From: Jamie Brown [REDACTED]
Sent: 18 May 2017 08:54
To: Gary Ferrier; Andrew Wood
Cc: Emma Avis; Dominic Smith
Subject: RE: 1 Sea Drive Subsitute Site plan submitted March 2017 (Local Highway Comments)

RE: Proposed development at 1 Sea Drive Ferring

From: Emma Avis
Sent: 20 March 2017 15:35
To: Andrew Wood
Subject: RE: Substitute amended Site Plan for informal advice at 1 Sea Drive

TITLE: BASEMENT PARKING VEHICLE
SWEEP PATH DETAILS

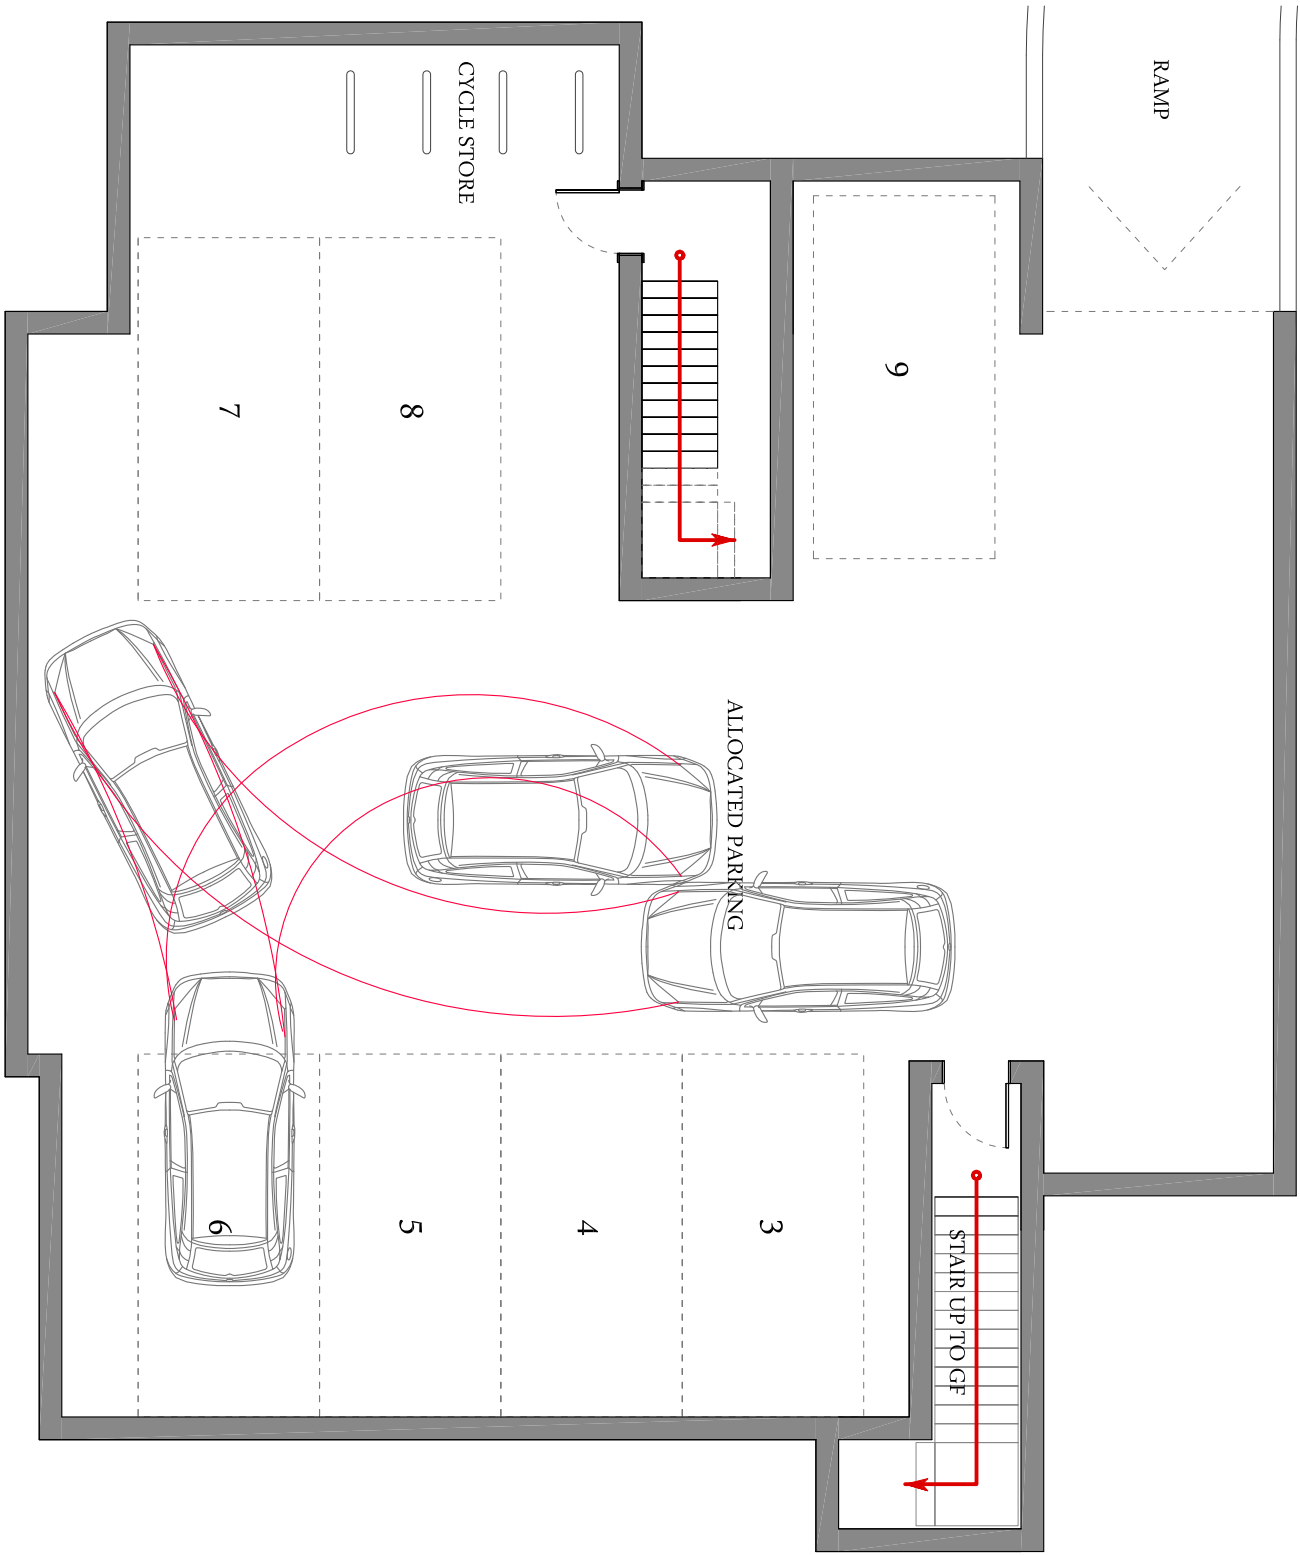
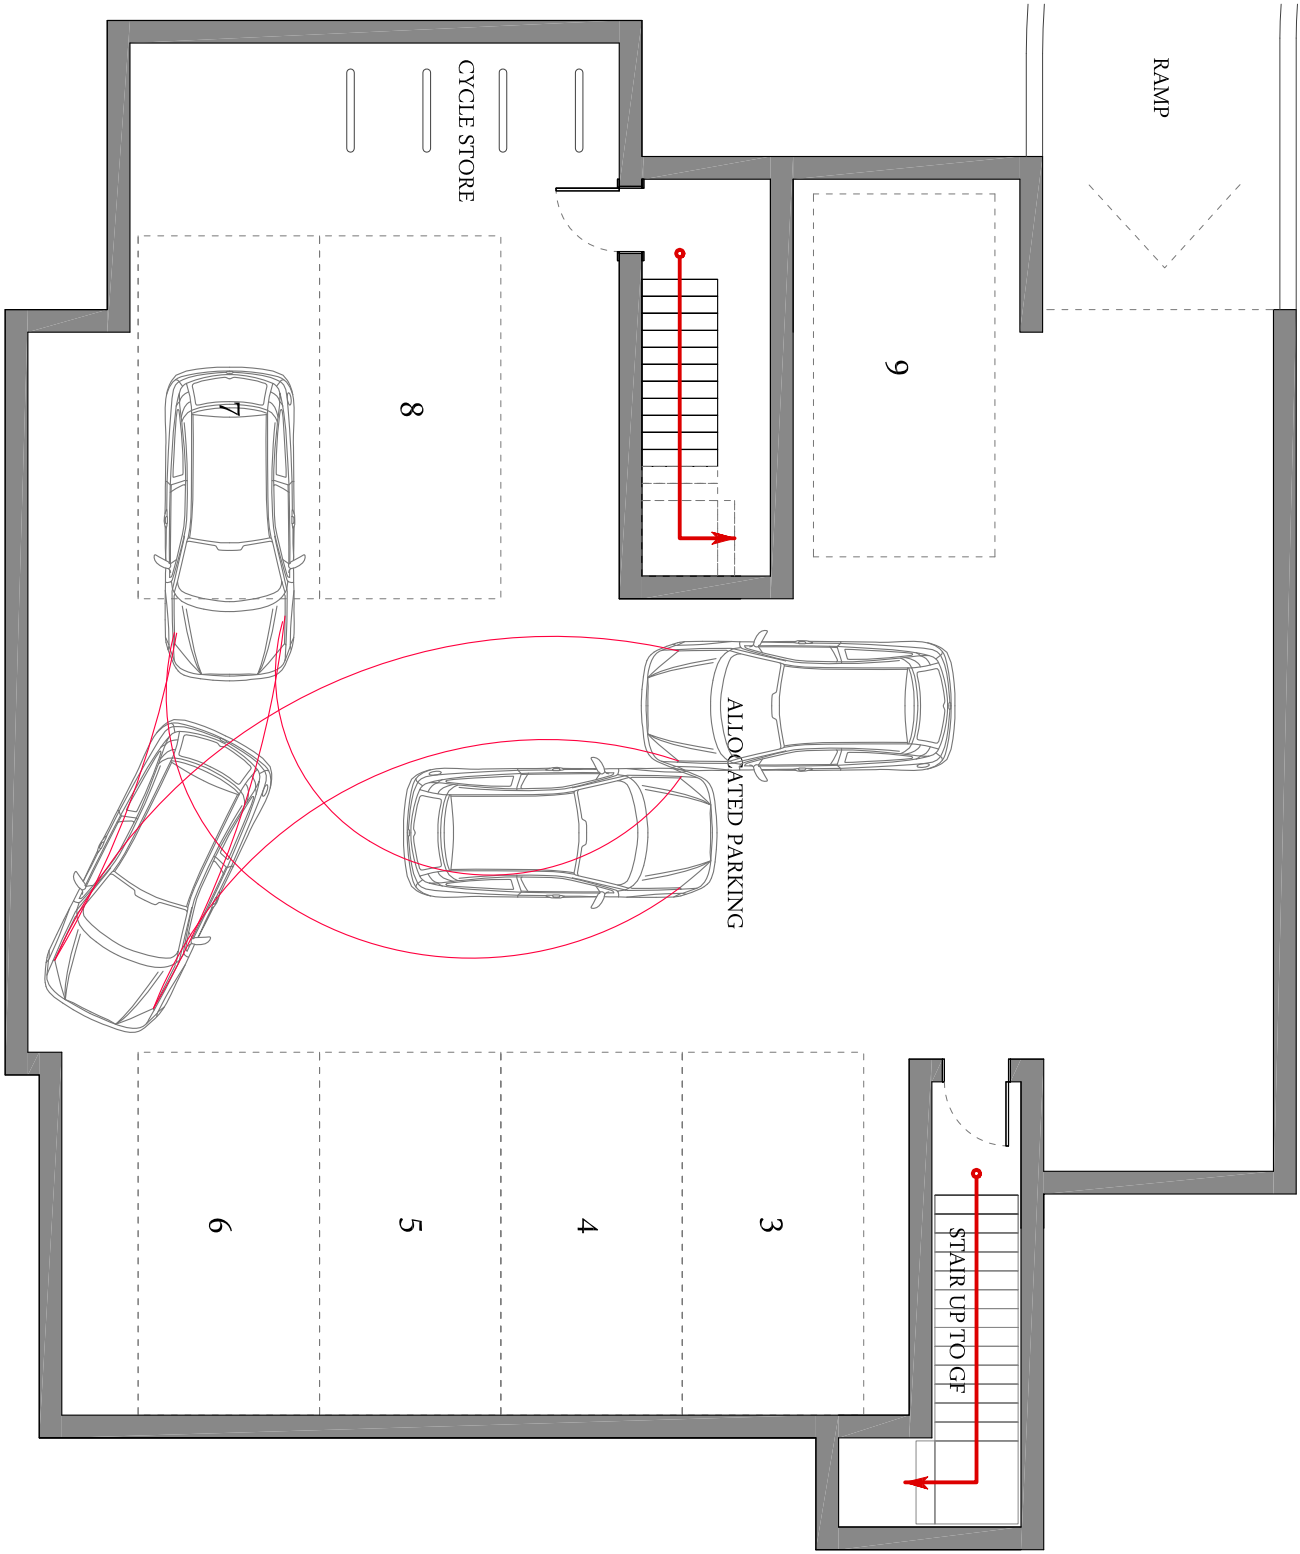
Thank you for the revised plan. I am looking at this case in Emma's absence, I have considered what appears to be the latest plan number PL002. I have read Emma's response from the 2nd May and am largely satisfied that the additional information overcomes the comments made in relation to the proposals. However I would seek more clarity on one area-turning space. Emma asked for swept path diagrams to be provided in support of the proposals in relation to vehicles entering and manoeuvring into bays 6 and 7. From what I can see on the aforementioned plan this has not been demonstrated can you confirm if this has been looked into and shown?

The underground parking area appears tight, vehicle tracking should be provided to demonstrate this is workable. In particular there is no turning head, it may be difficult for vehicles to get into and out of bays 6 & 7 and should a vehicle enter and all spaces are taken then it would involve them reversing out up the ramp, this is not ideal.

Thank you for that. I am satisfied that this additional plan overcomes the points made regarding turning.

Please find attached a plan showing the vehicle swept path details as requested.
